Our Case Number: ABP-318093-23

An
Bord
Pleanála

Date: 09 July 2024

Re: Proposed road development at The Quay, Quay Street, Suir Island and Raheen Road
The Quay, Quay Street, Suir Island and Raheen Road, Clonmel County Tipperary

Client
TIPPERARY COUNTY COUNCIL
 Project
SUIR ISLAND INFRASTRUCTURE LINKS
 Preferred Option 01 Public Lighting Services Layout Plan

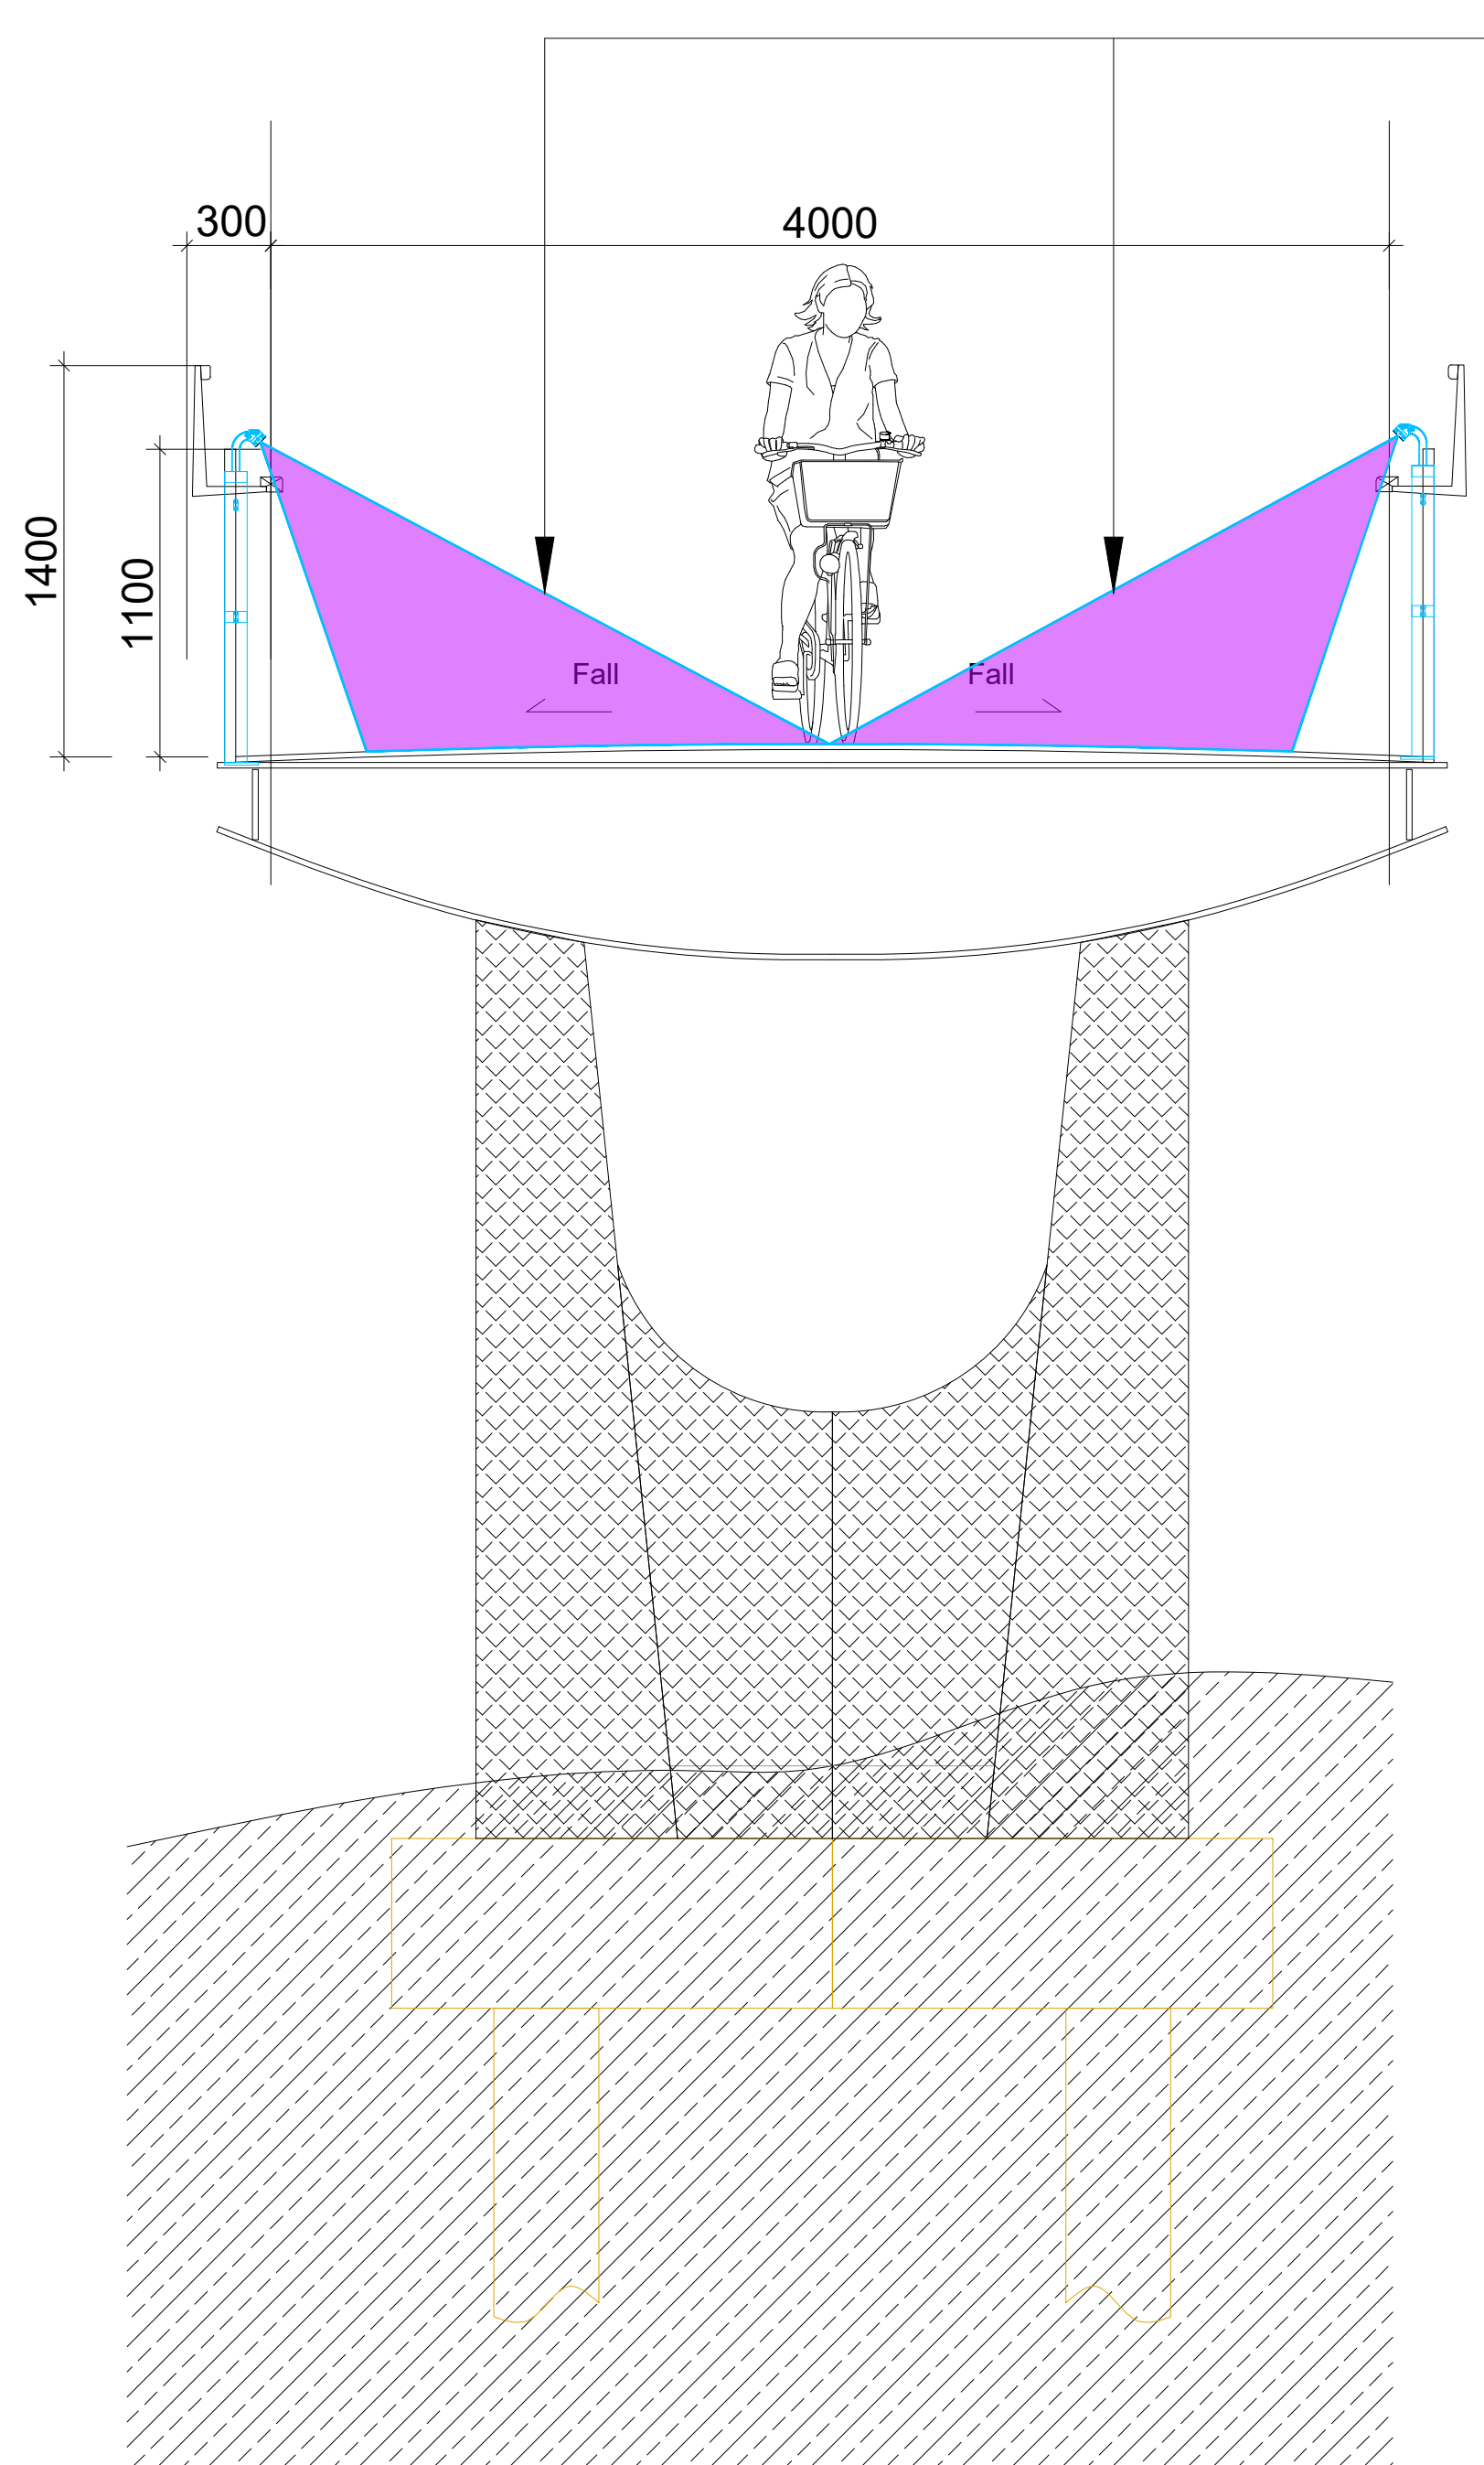
(iii) Consideration should be given to the potential impact of lighting on otter species at construction and operational stages.

e) The Conservation Objective for Otter (1355) in the Lower River Suir SAC (002137) seeks to maintain the favourable conservation condition. The NIS should outline if likely significant effects will arise on foraging otter by way of general noise and lighting impacts at both construction and operational stages, having regard to appropriate mitigation measures.

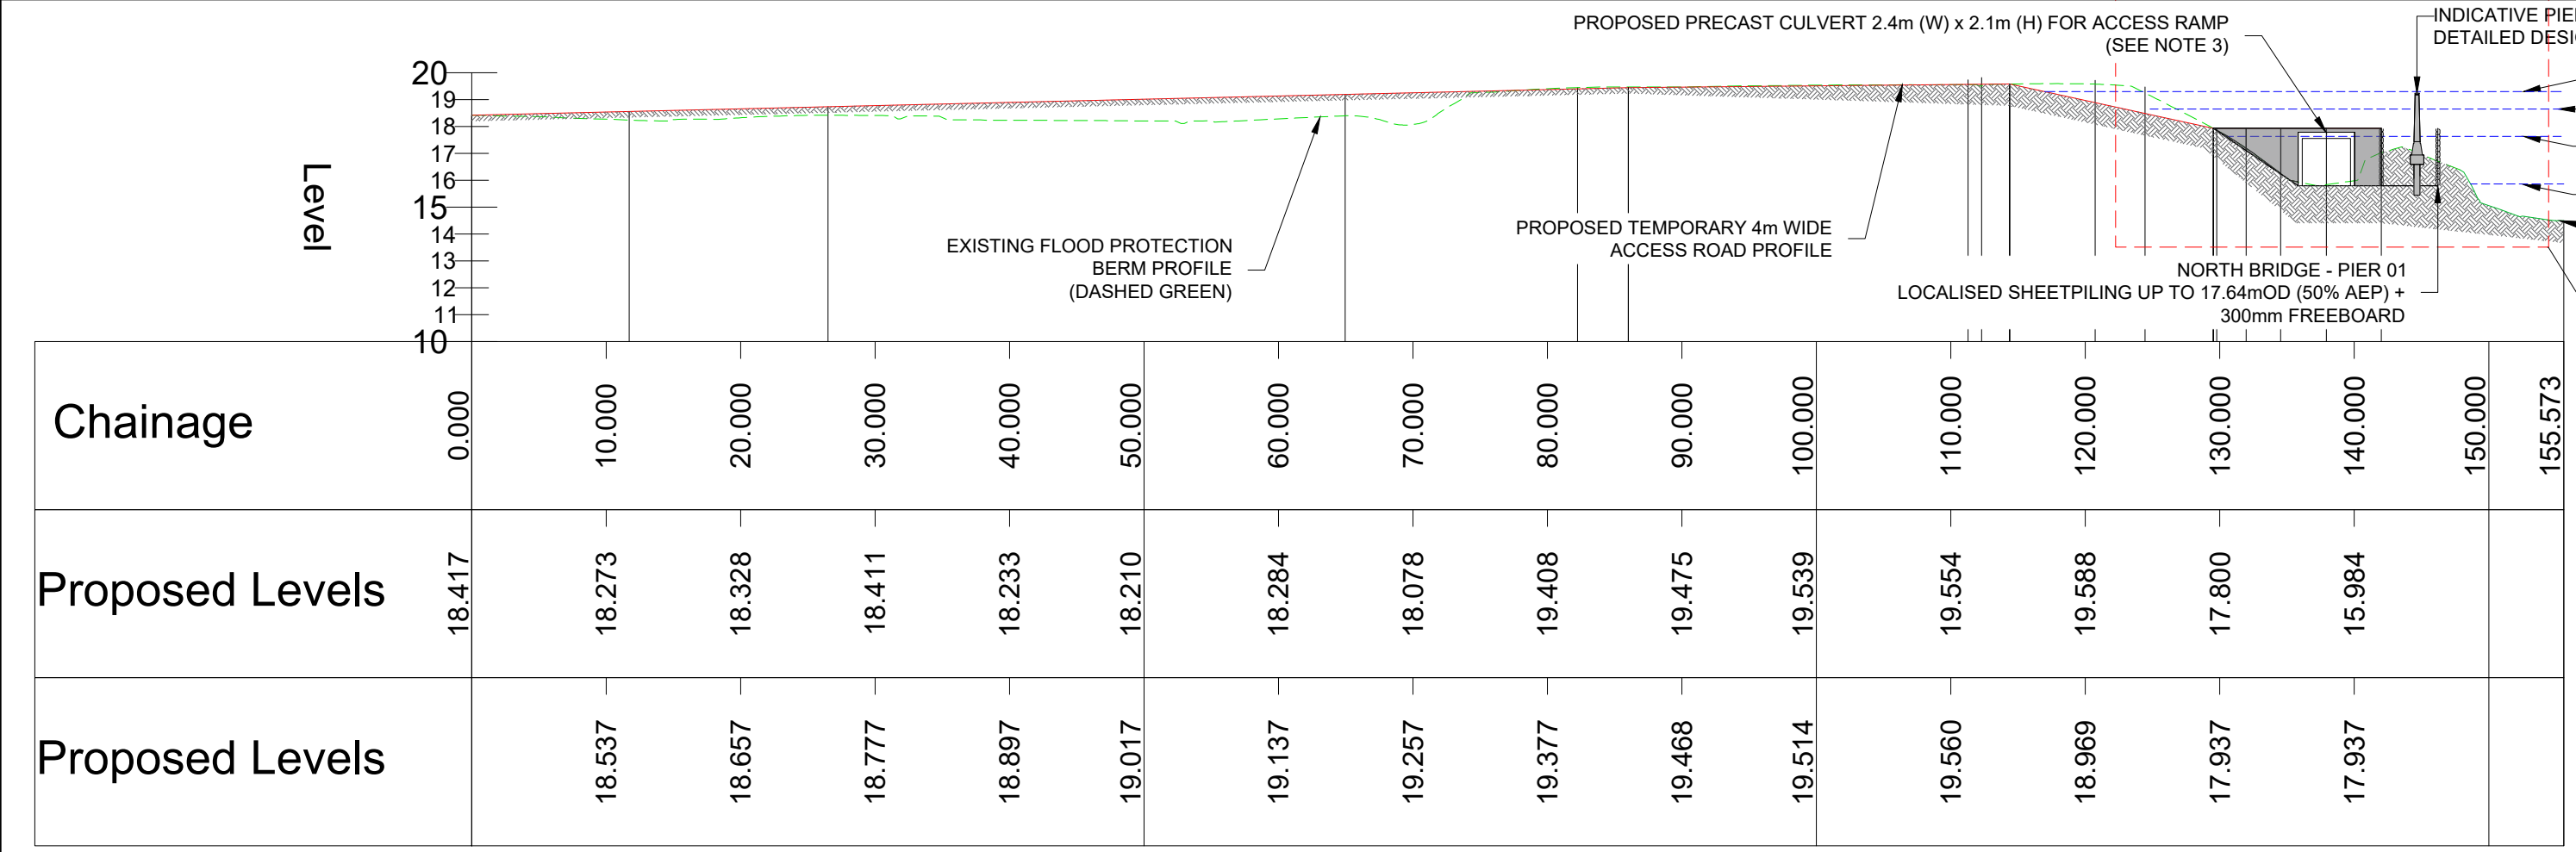
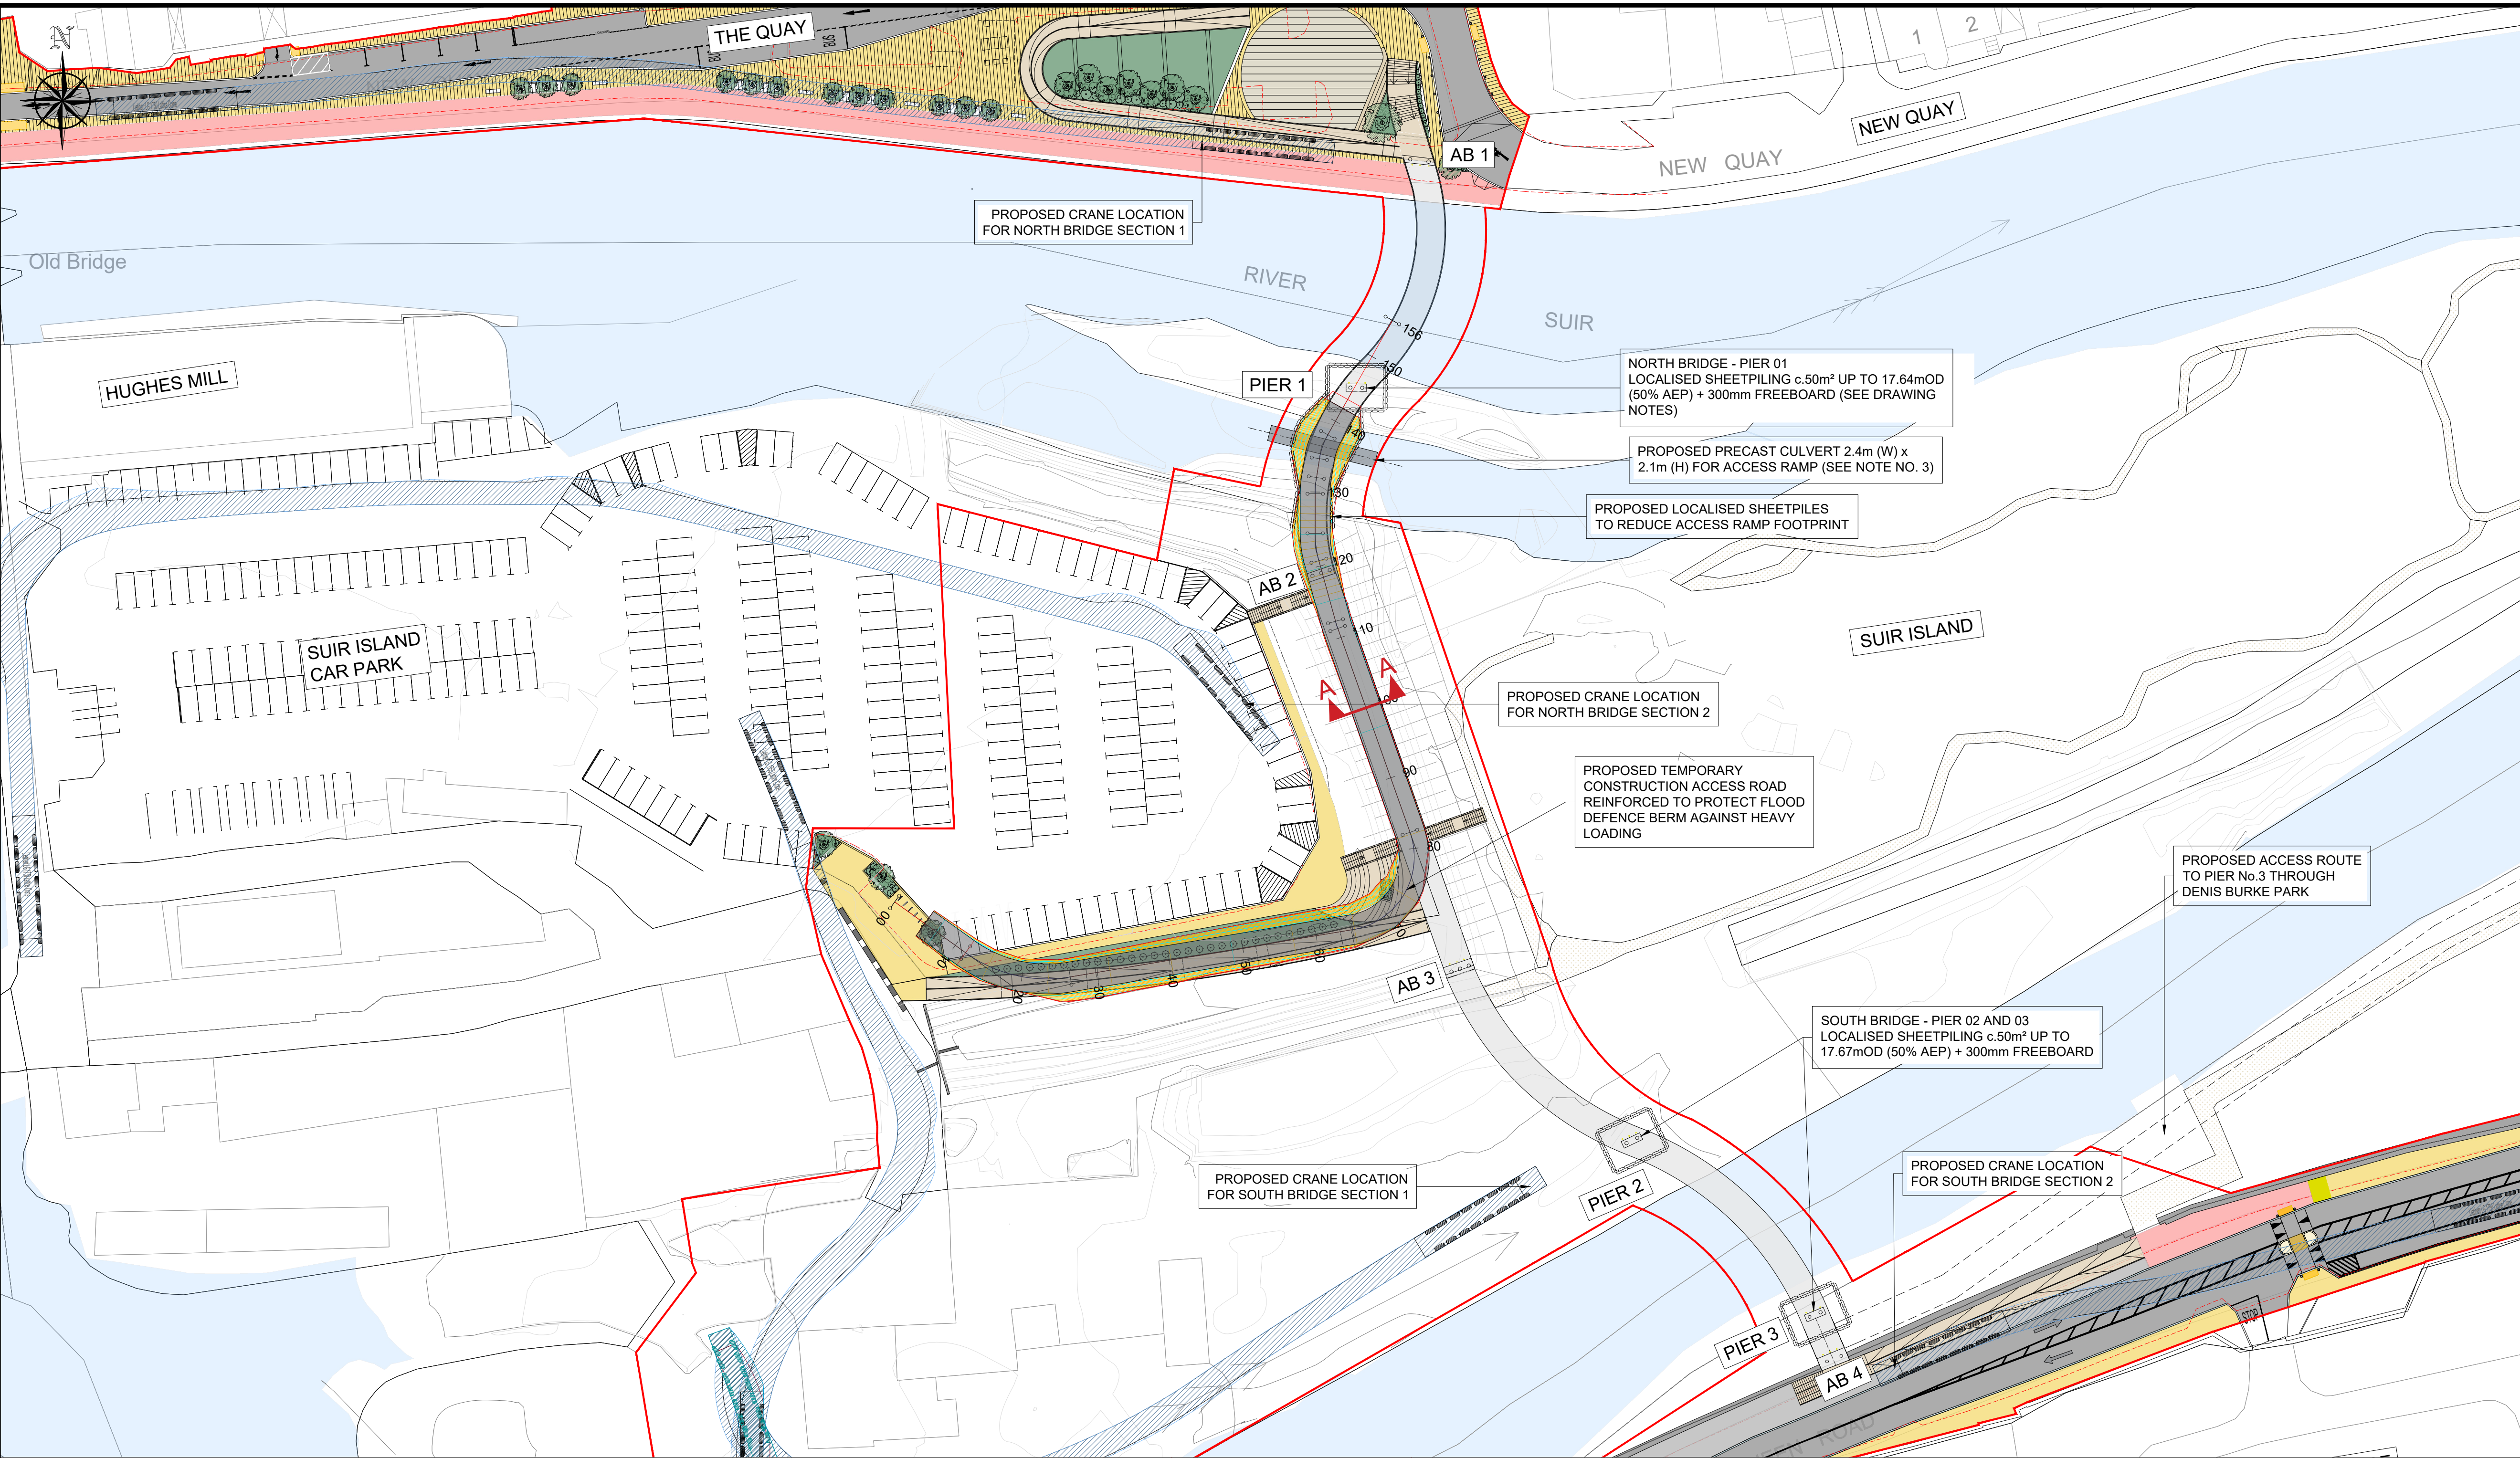
(i) The EIAR outlines there will be no in-stream works and no direct loss or disturbance to instream habitats. However, the proposed development includes for the construction of temporary access ramp and installation of a pre-cast box culvert at the site area of a back-water flood channel to the south of Pier 1 which conveys water during flood events, with sheet piling proposed at this location. From application drawings submitted, the ground level of the culvert corresponds to the approx. base flow as indicated on plans (drawing no.2460) and is below the 1%, 10% and 50% AEP. It is also noted that proposed piers and abutment works located within the flood barriers/defences are below the level of AEPs, which is particularly the case for the proposed southern bridge (drawing no.2260). While it is noted that works will be timed to avoid flooding and will be temporary in nature, given the levels outlined and potential for flooding, consideration should be given to the potential impacts arising from instream works, and from instream works arising in periods of increased base flow and flooding. In the event of

c) The NIS outlines the project will not involve any instream works that could result in the loss of instream habitats. However, the proposed development includes for the construction of temporary access ramp and installation of a pre-cast box culvert at the site area of a back-water flood channel to the south of Pier 1 which conveys water during flood events, with sheet piling proposed at this location. From application drawings submitted, the ground level of the culvert corresponds to the approx. base flow as indicated on plans (drawing no.2460) and is below the 1%, 10% and 50% AEP. It is also noted that proposed piers and abutment works located within the flood barriers/defences are below the level of AEPs, which is particularly the case for the proposed southern bridge (drawing no.2260). While it is noted that works will be timed to avoid flooding and will be temporary in nature, given the levels outlined and potential for flooding, consideration should be given to the potential impacts arising from instream works, and from instream works arising in periods of increased base flow and flooding. In the event of potential impacts being identified, appropriate mitigation measures addressing same are to be outlined, where applicable.
